PLANNING APPLICATION REPORT**REF NO:** FP/217/08/**LOCATION:** 4 Felpham Road
Bognor Regis**PROPOSAL:** Conversion and change of use of existing residential care home to 4 no private flats (Resubmission of FP/99/08)**SITE AND SURROUNDINGS**

PROPOSED SECTION ON C-C

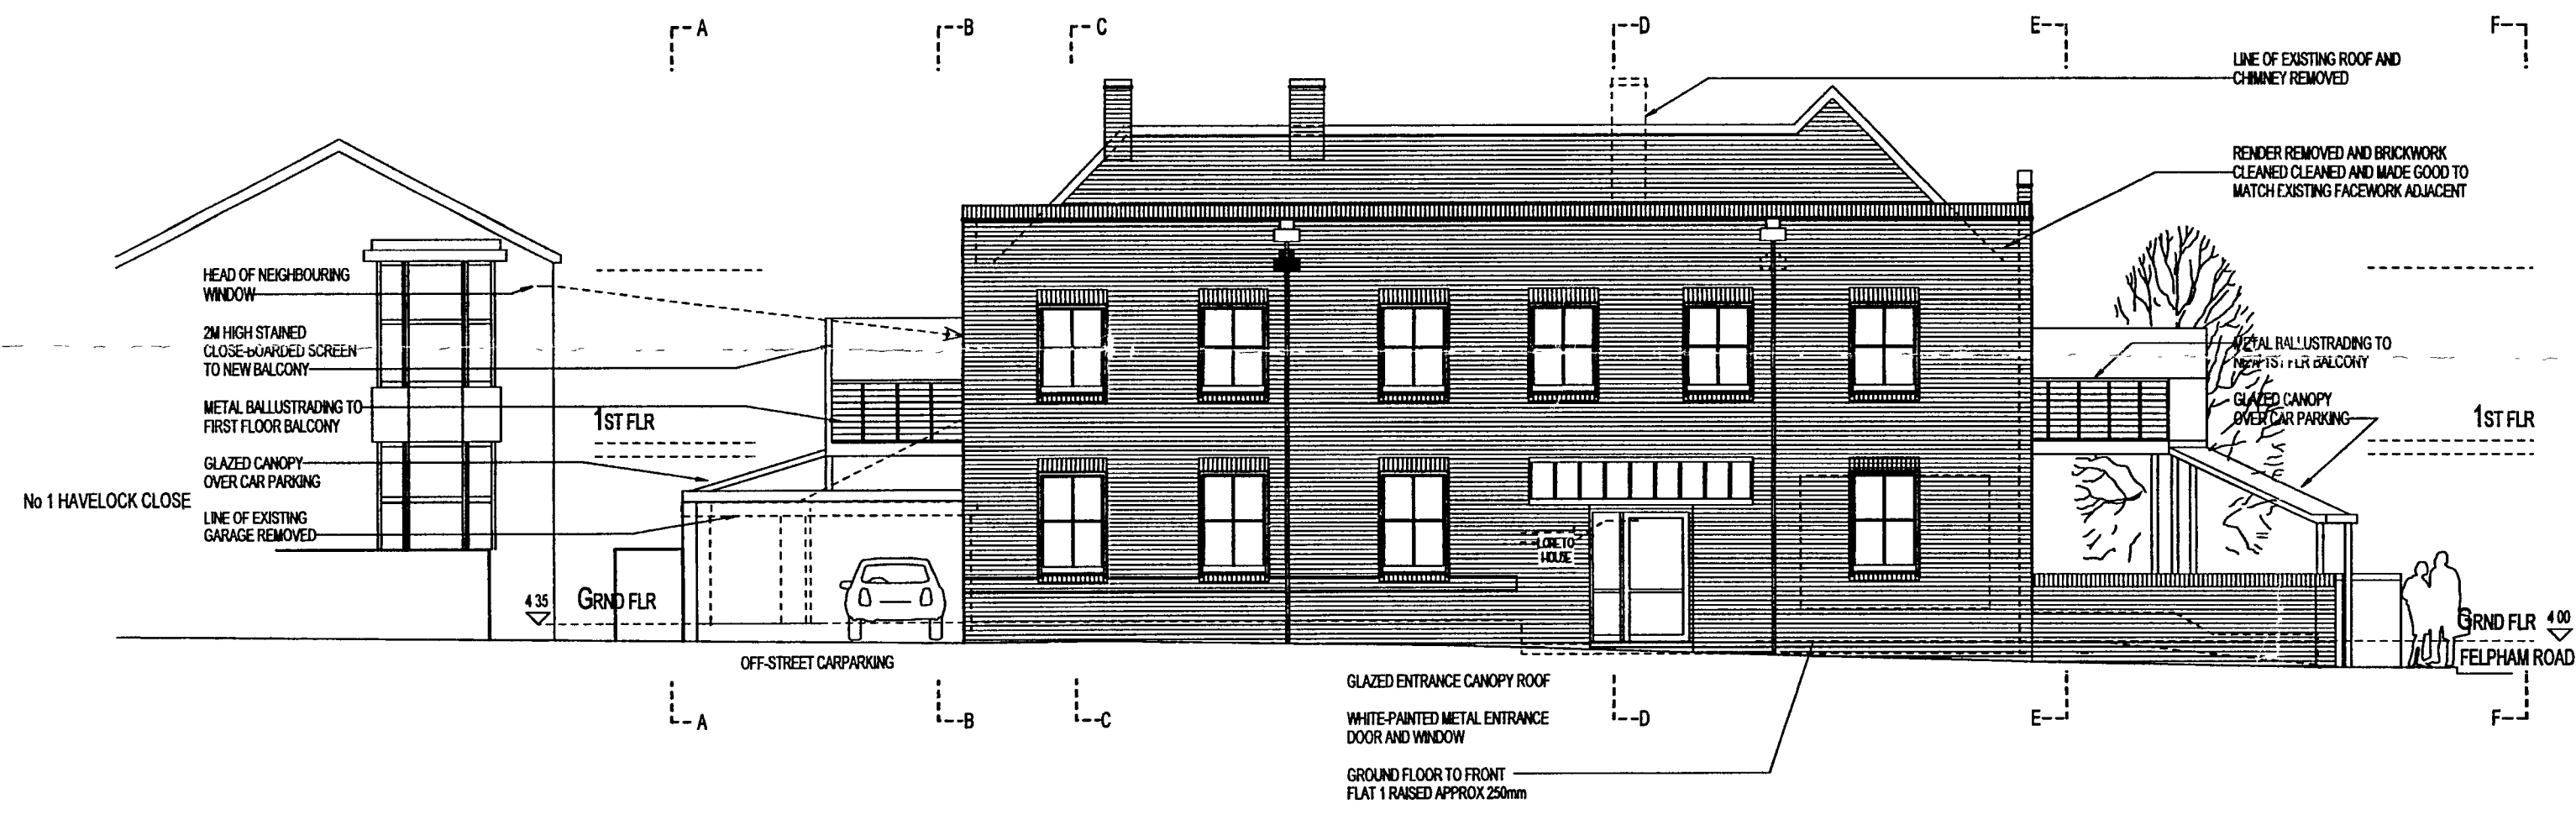
One letter of objection : the residents of Havelock Close have not been consulted. The proposed lean to over the first floor bedroom will directly face neighbouring windows. Will external lights be affixed? Parking is a problem and insufficient parking is proposed. Cannot read plans on the website very well.

The south elevation is the rear elevation which fronts onto the car park area of the adjacent flats. The proposal is to raise the parapet wall 2.6m and to introduce high level glazing. The fenced enclosed balcony 2m high is the only other alteration on this elevation.

The east elevation introduces a 2m fence over a balcony with minor changes to fenestration and glazing over the side of the carport.

The changes that could potentially adversely affect the residential amenity of neighbouring properties is the use of the proposed balconies. However, these are being screened with 2m high opaque glass screens which will be permanently fixed. Therefore there is no potential for overlooking neighbouring properties. The balcony to the front of the site only directly overlooks the river embankment and does not directly overlook any neighbours. However, as the front elevation is onto a busy public road, it is considered that a balcony of 2.2metres is too large in depth, particularly as this is accessed from a principal room.

The first floor balcony is screened with 2m high opaque glazing and therefore there can be no direct overlooking of neighbouring properties. It could be conditioned that there is no external lighting. An orange site notice was posted on the lamp post outside the site, neighbour notification is not a policy of this Authority.
